**Subject:** RE: Attached letter from Kirklees Council regarding application number 2019/90502 at location Land off, Fernside Avenue, Almondbury, Huddersfield, HD5 8PH

Unfortunately, there are a number of concerns that remain on this application in terms of bringing up the access to adoptable standard, which will be required given it is expected to serve ten dwellings. Having spoken to senior officers about this proposal, the issues raised are as follows:

SCALE: 1:250 @A3
 DATE: FEB 2019
 DRAWING NO: 1901502

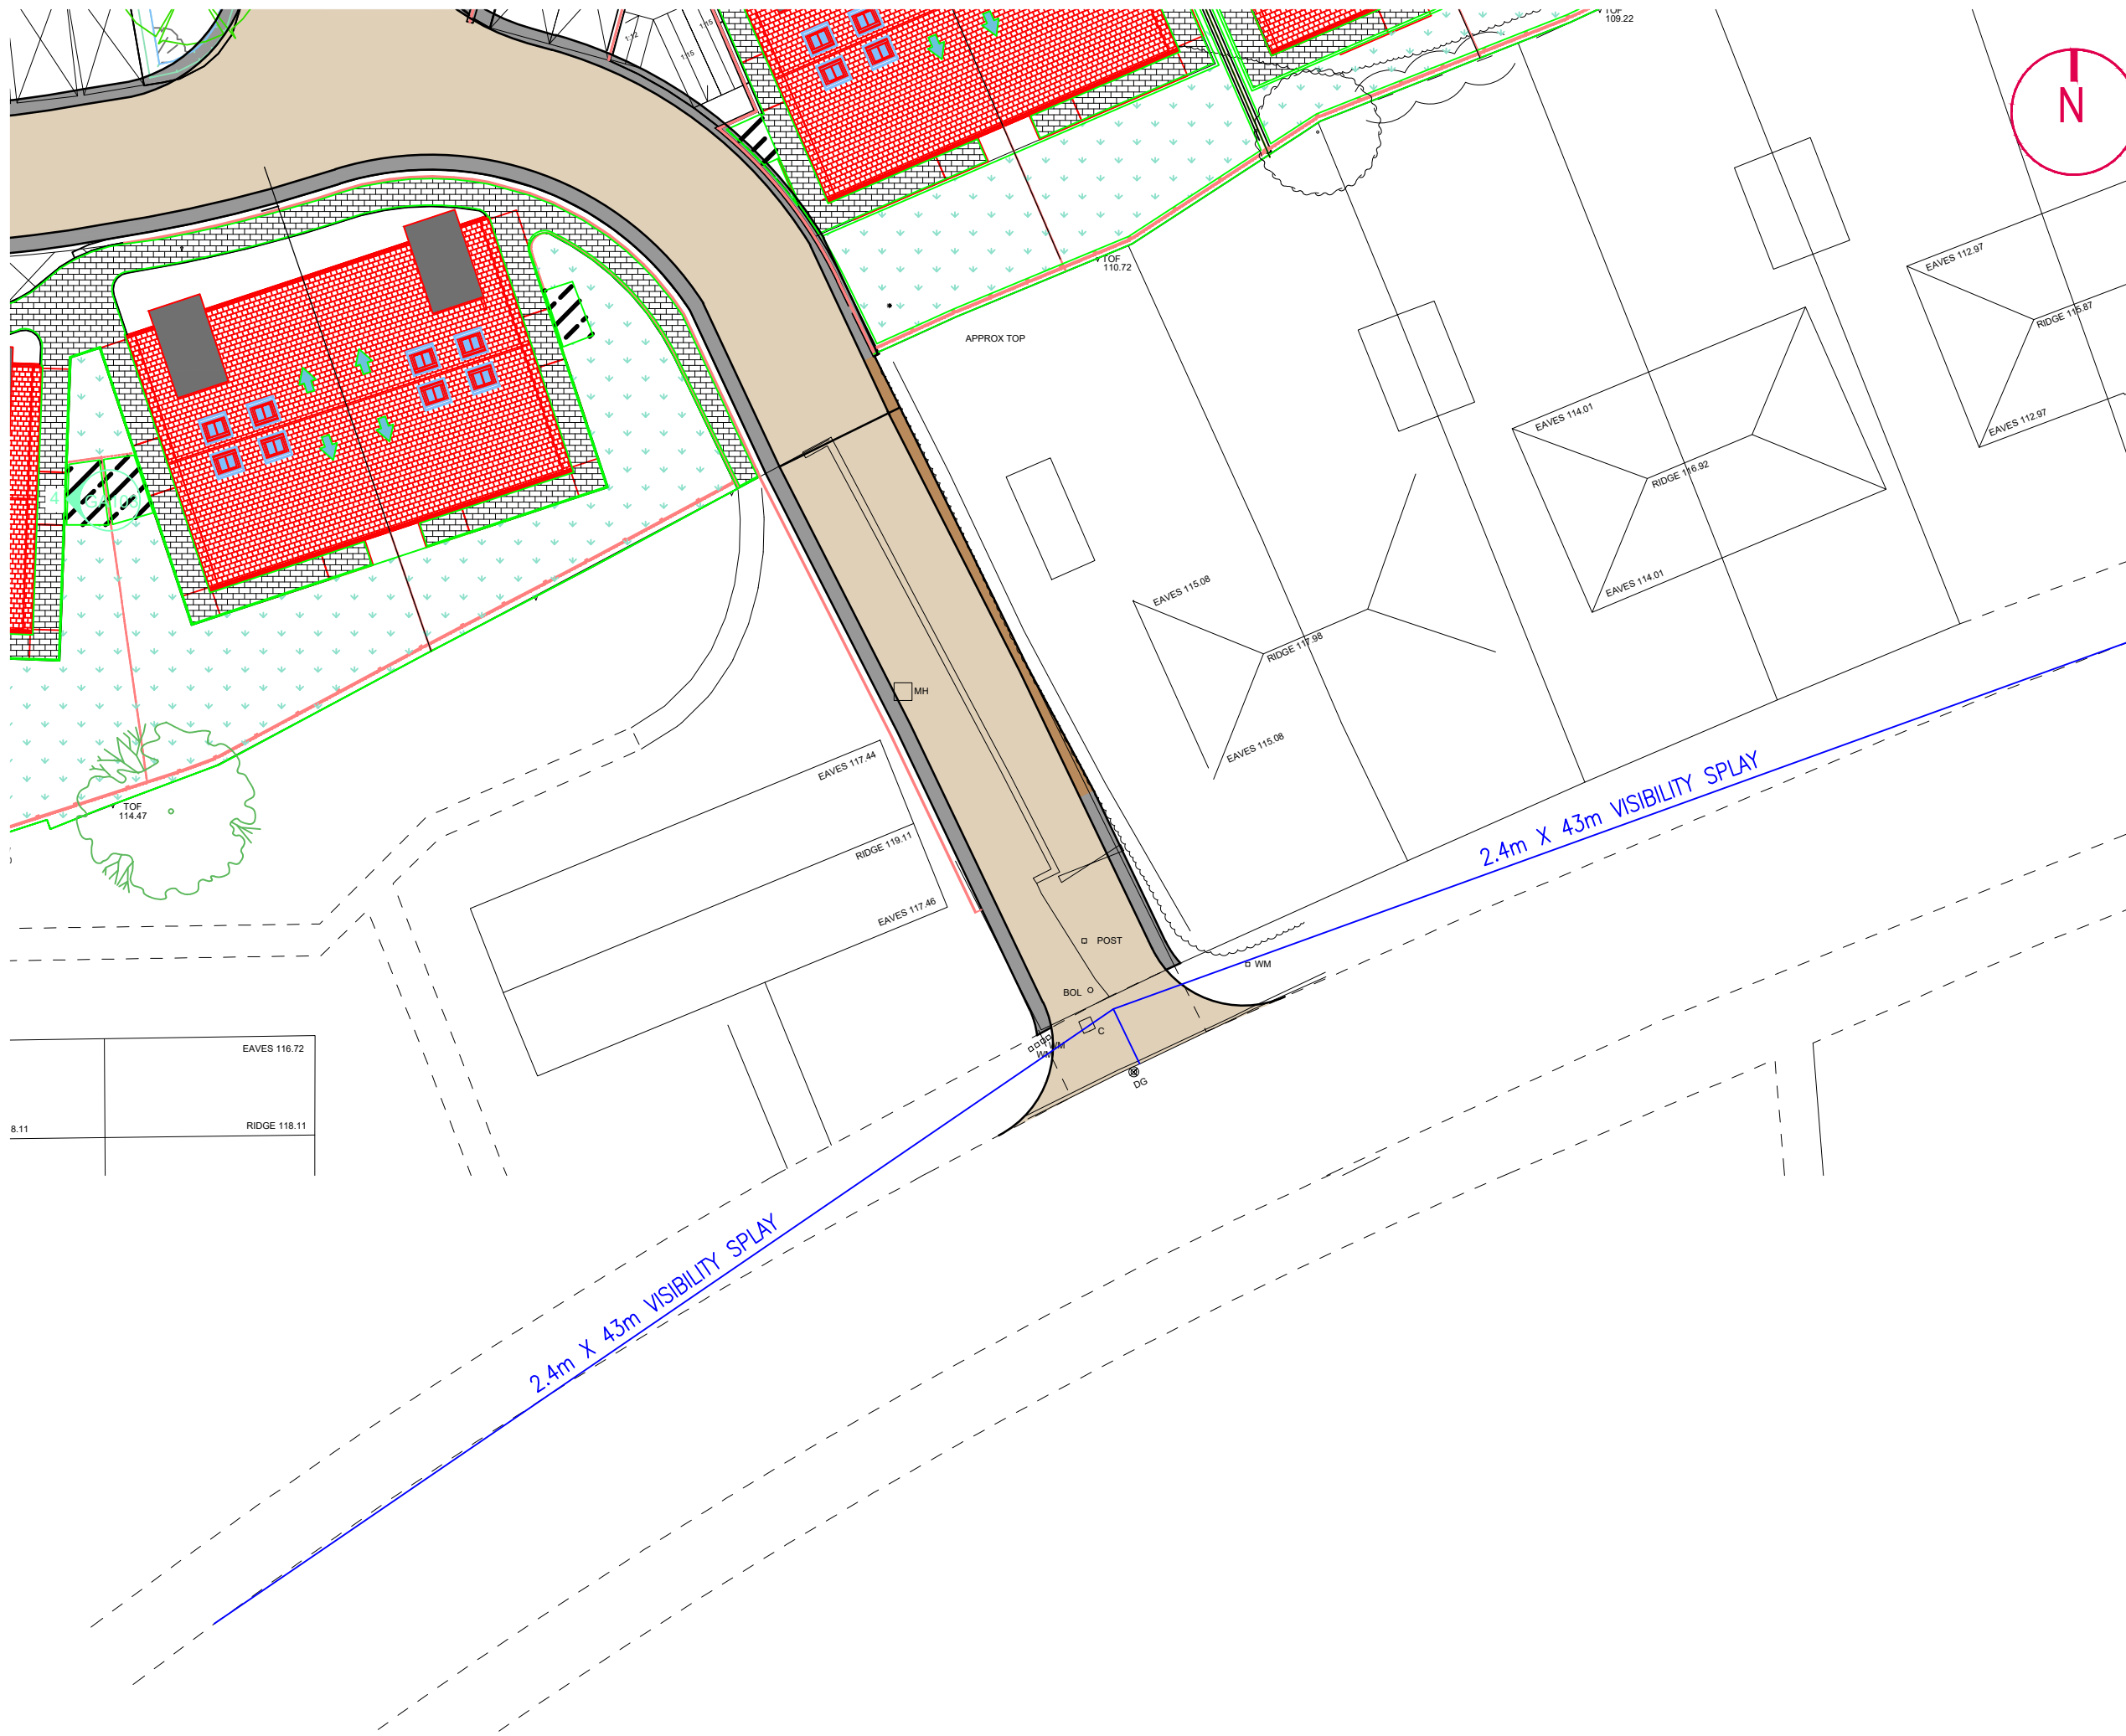
- The gradient being over 1:10 (and over 1:25 for the first 10m).
- The lack of footway leading into the site up to a calming feature.
- The inability to supply a hard margin of 0.6m when leading into the site (and thus where the utilities will be laid).
- The width of 4.8m for the access road given the relatively busy nature of Fernside Avenue.
